Fw: Application BR/203/25/PL - Trevali, Belmont St

Subject: RE: Application BR/203/25/PL - Trevali, Belmont St

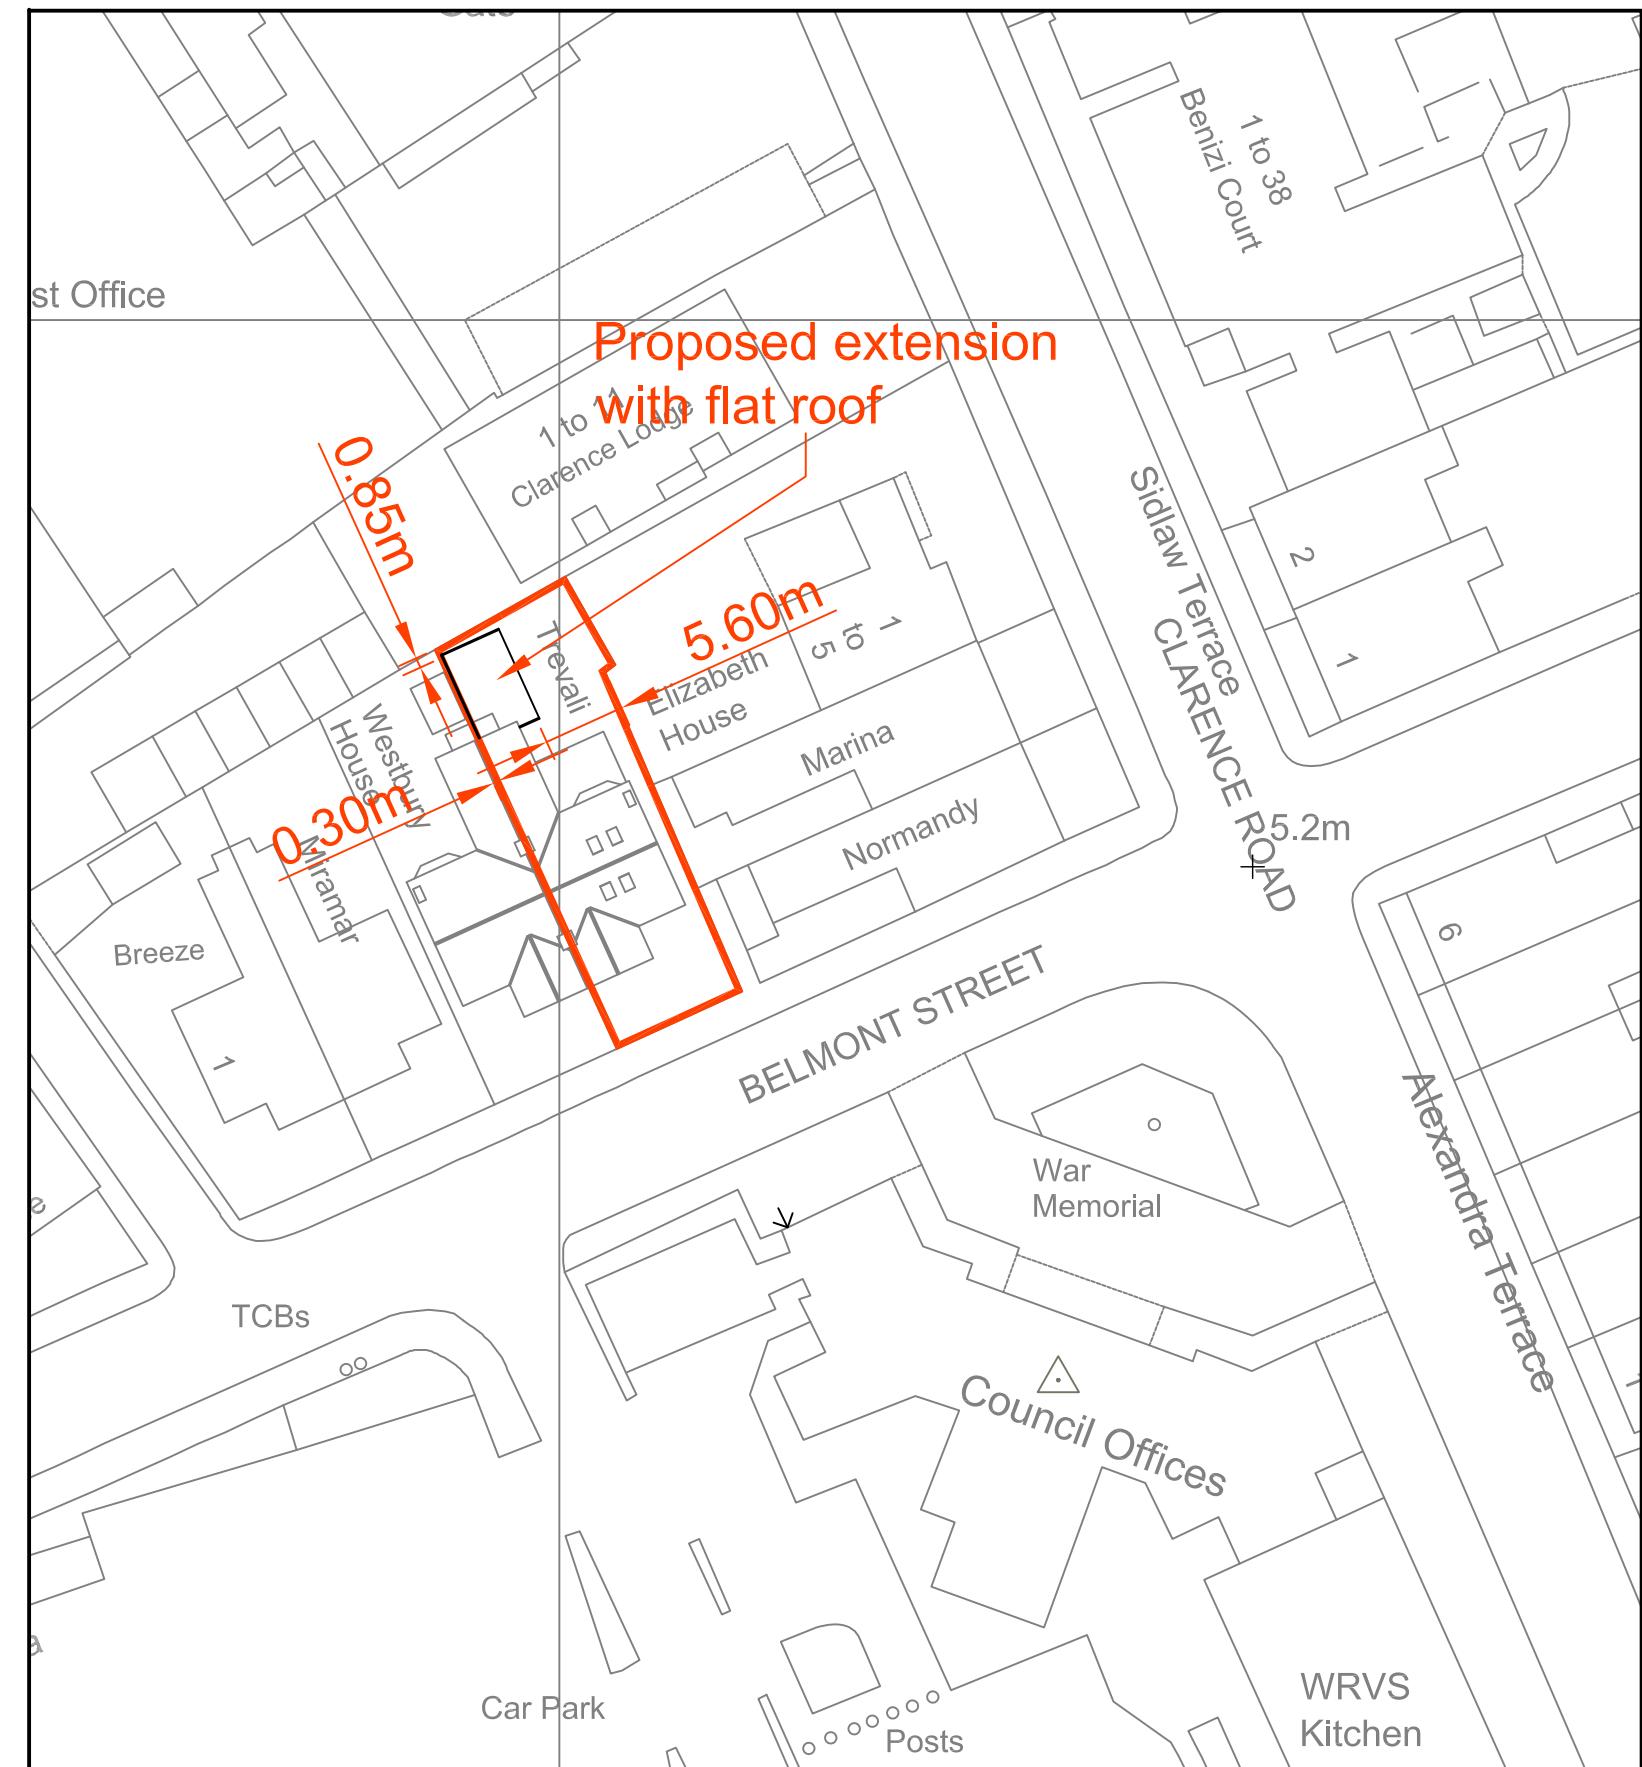
Following my last email, I have also noticed that the block plan has an annotation for a proposed extension on it. As the extension has already been constructed and no operational development is proposed under this application, please could this be removed?

- Revised Block Plan (ref: CBL-1025450-B101)
- Stat Dec (completed by owner)
